Application no: 3/2019/0763

Address: Land off Ribblesdale View , Chatburn  
Proposal Variation of Conditions

The proposal seeks to amend the wording of a number of conditions relating to the planning permission granted for app 3/2018/1179. Of interest to the highway authority are conditions 12 and 14.

SJ Bialecki Limited Building Surveyors
Drawing no 6002/d
Scale 1:100
Proposed Site Layout
Proposed Residential Development On Land At Ribblesdale View Chatburn

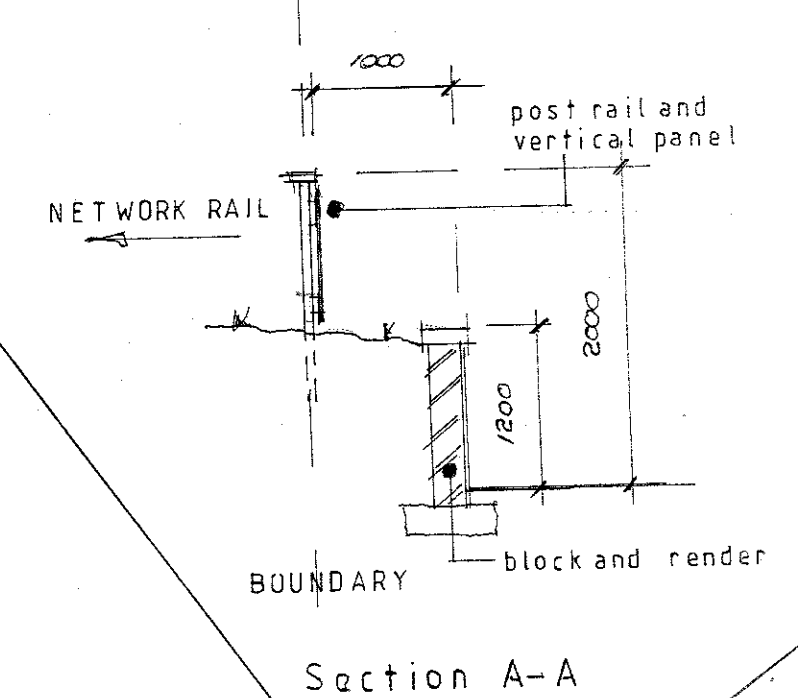
Condition 12 relates to the Ribblesdale View frontage and seeks to delay compliance from ' prior to commencement' to 'prior to occupation'. This would not be acceptable. The visibility concerns would extend to construction traffic attending the site and should therefore be completed prior to commencement.

Condition 14 relates to the highway works and similar to the above and seeks to delay compliance from ' prior to commencement' to 'prior to occupation'. Whilst it is not the intention of the applicant to have the estate road adopted , the highway authority would need to be satisfied that its connection onto the adopted highway is completed to the correct standard before the site is accessed by construction vehicles and suitable, post completion, for access to the dwellings on the estate. Consequently the revised wording of the condition would not be acceptable.
